<b>EL PASO COUNTY CONSERVATION DISTRICT</b>		
1.	Recommends where ground is disturbed, it should be mulched or re-vegetated within 45 days of disturbance. Please make sure any native grasses already in place are truly native to the area. If there is no noxious weed control plan in place, we recommend that an integrated weed management program be reviewed and approved.	Noted.
<b>PCD PROJECT MANAGER – SERVICE PLAN COMMENTS</b>

**DA DAVIDSON LETTER**

Exhibit A-3
Proposed Infrastructure and Amenities Map

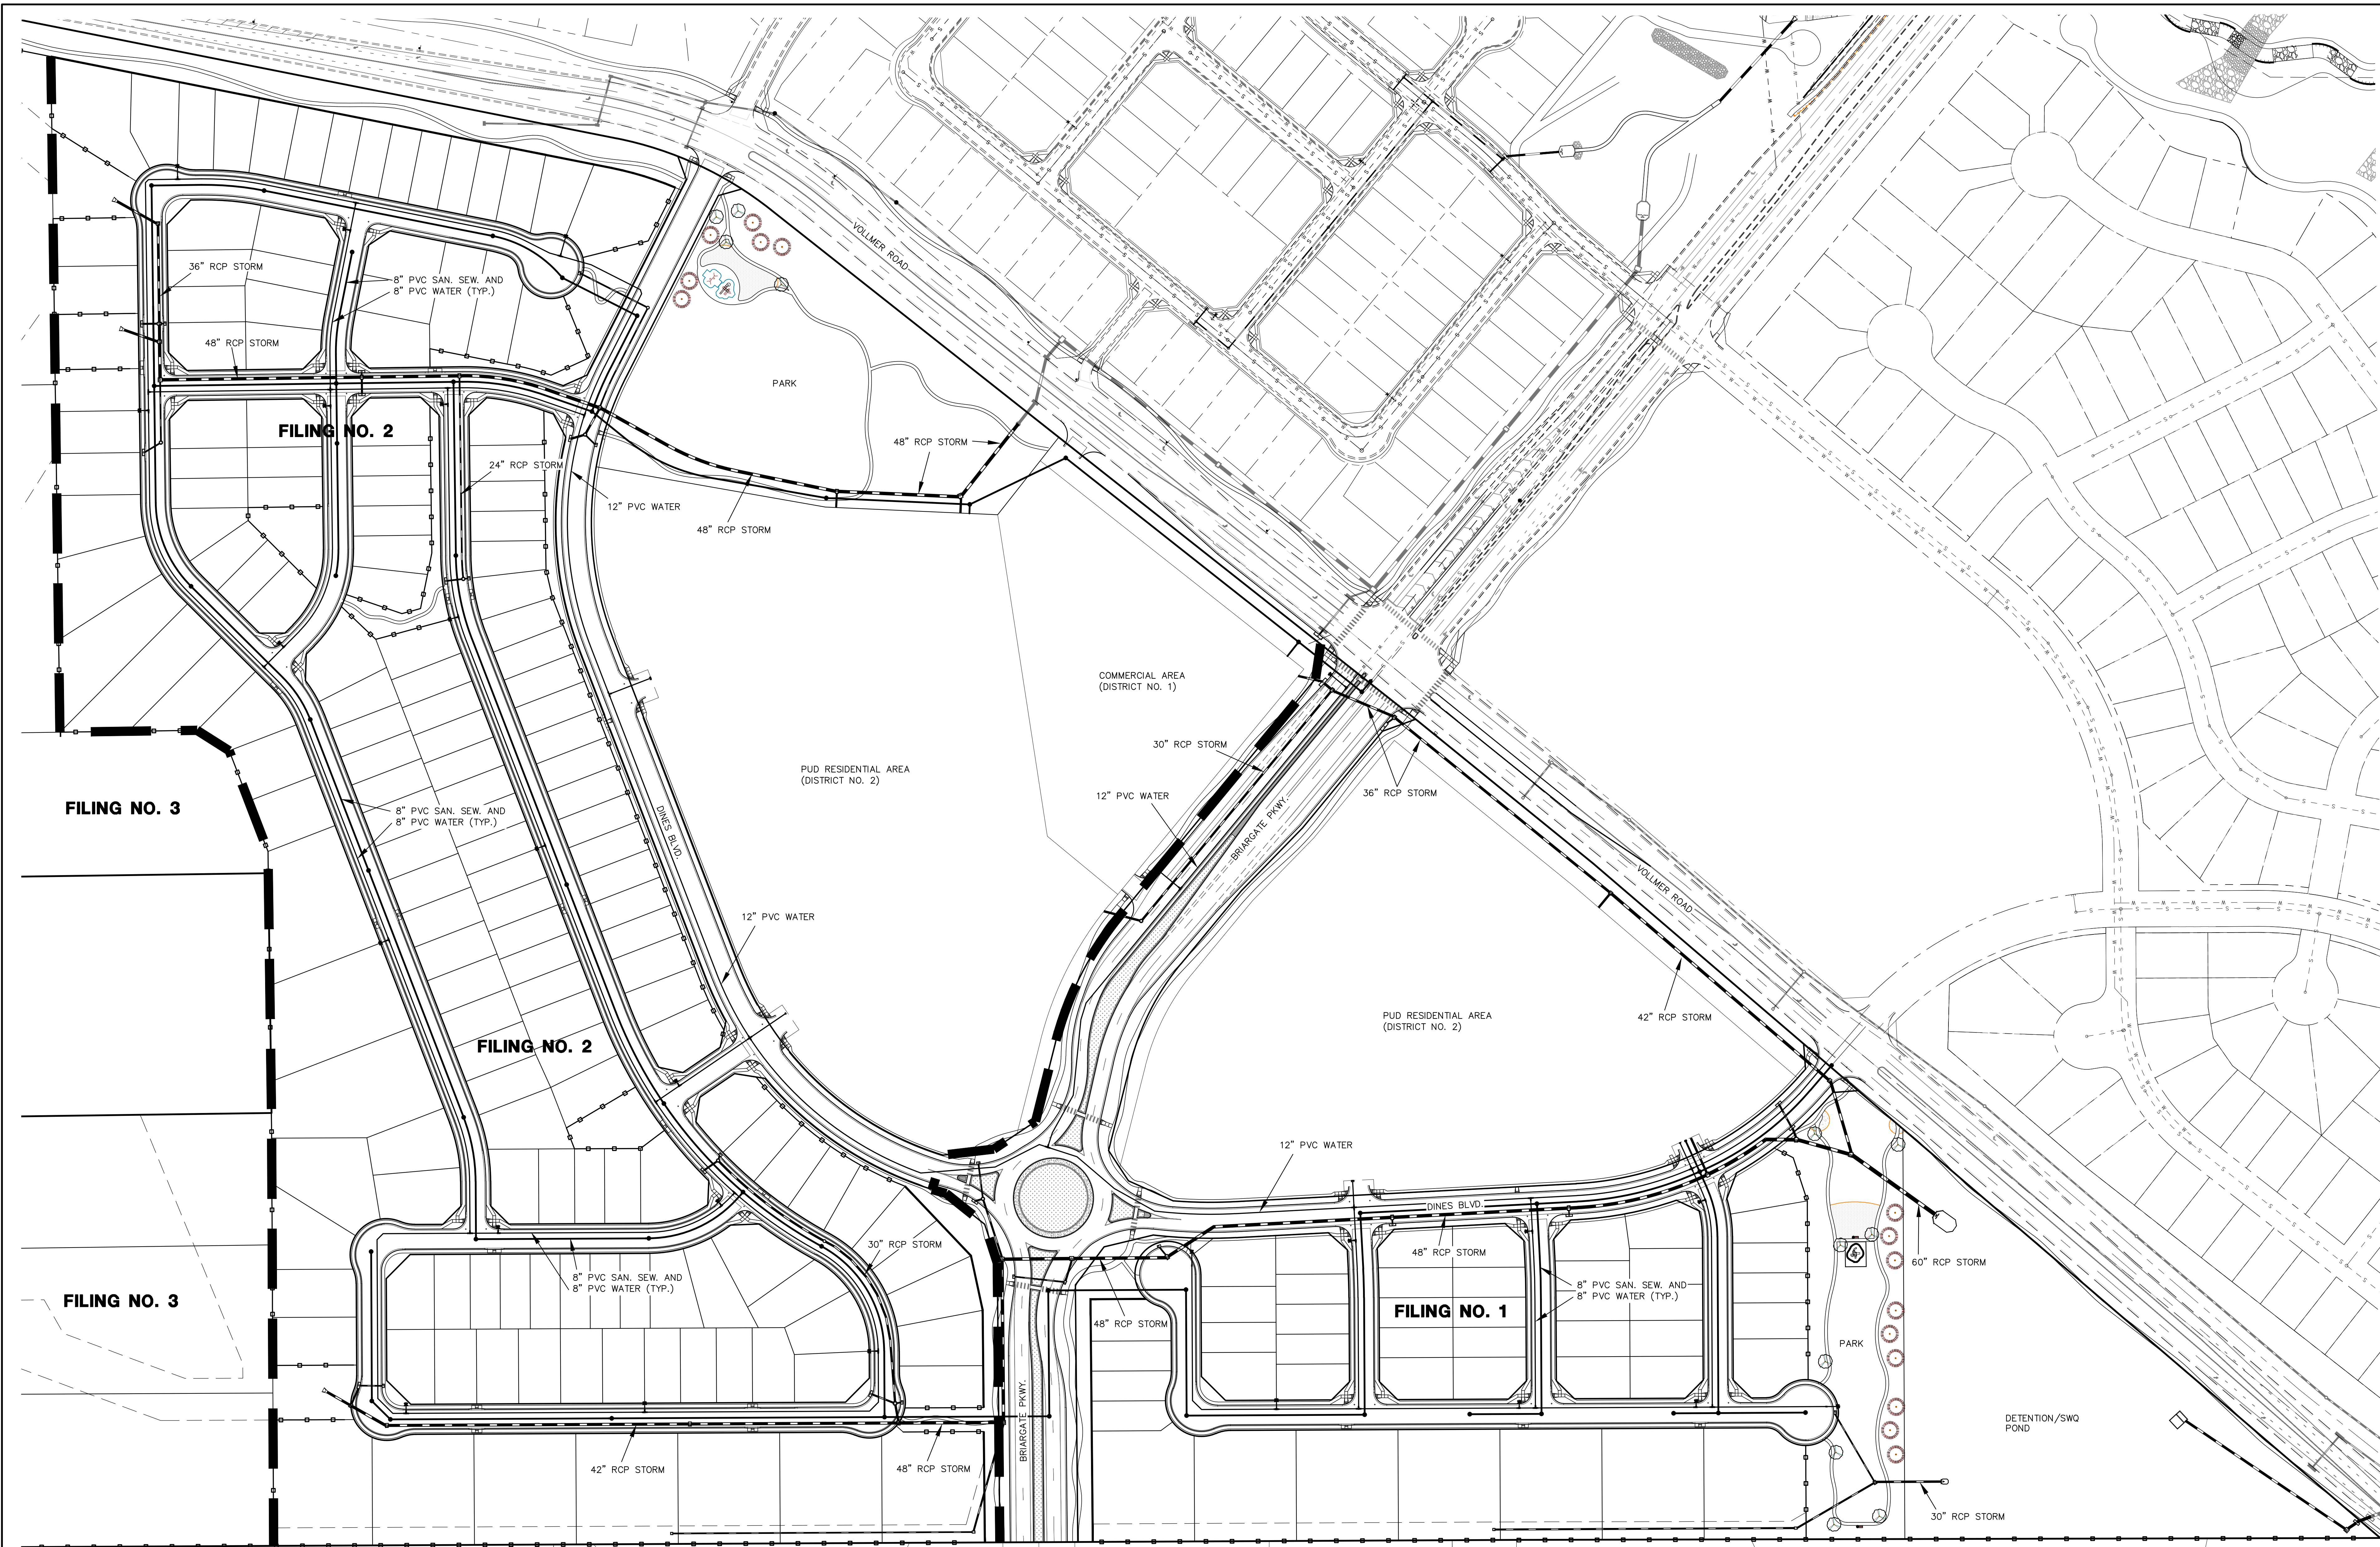
<p>VII.A. Is this going into County Road Impact Fee PID too?</p>	<p>As stated above, the PIF will be used to help fund public improvements and the Districts’ operations.</p>
	<p>Page 21. The creation of a Citizens Advisory Council may come up at hearing.</p>	<p>Noted.</p>
	<p>Exhibit A-3 Proposed infrastructure and Amenities Map. Open space park drainage map; water wastewater infrastructure map; roadway map; the cds are too busy and confusing to be an exhibit. We don’t see that typically.</p>	<p>An updated exhibit is attached to the Service Plan.</p>
	<p>Recommends an exhibit showing the range of houses since critical to finance plan.</p>	<p>A Sketch Plan will be uploaded to EDARP.</p>
	<p>Exhibit B. Development Summary. 3-year build out seems very aggressive. What study was used to determine this?</p>	<p>Please see the comment below regarding comps.</p>

8.	III.E.4. – Add how many detention ponds will be designed, constructed, owned and maintained.	Only one detention pond is anticipated at this time.
	III.E.5- How many acres/miles of open space, parkland and trails will be owned and maintained by the District?	Revised. It is anticipated that there will be 22.9 acres of open space, parks, and trails.
	<p>III.E.7.- Fire Protection Modify this to include fire hydrants.</p> <p>breeding grounds and purchase, lease, contracting or other use of equipment or supplies for mosquito control.</p> <p>modify this to include Hydrants</p> <p>7. <b>Fire Protection.</b> The Districts shall not be authorized to plan for, design, acquire, construct, install, relocate, redevelop, finance, operate, or maintain fire protection facilities or services, unless such facilities and services are provided pursuant to an intergovernmental agreement with the applicable fire district. The authority to plan for, design, acquire, construct, install, relocate, redevelop, or finance fire hydrants and related improvements installed as part of the water system shall not be limited by this provision.</p>	The language included in the draft Service Plan is the same language that is included in the approved Service Plans for Flying Horse North MD Nos. 1-5 and Sterling Ranch Metropolitan District Nos. 4 & 5. We did not revise this language.
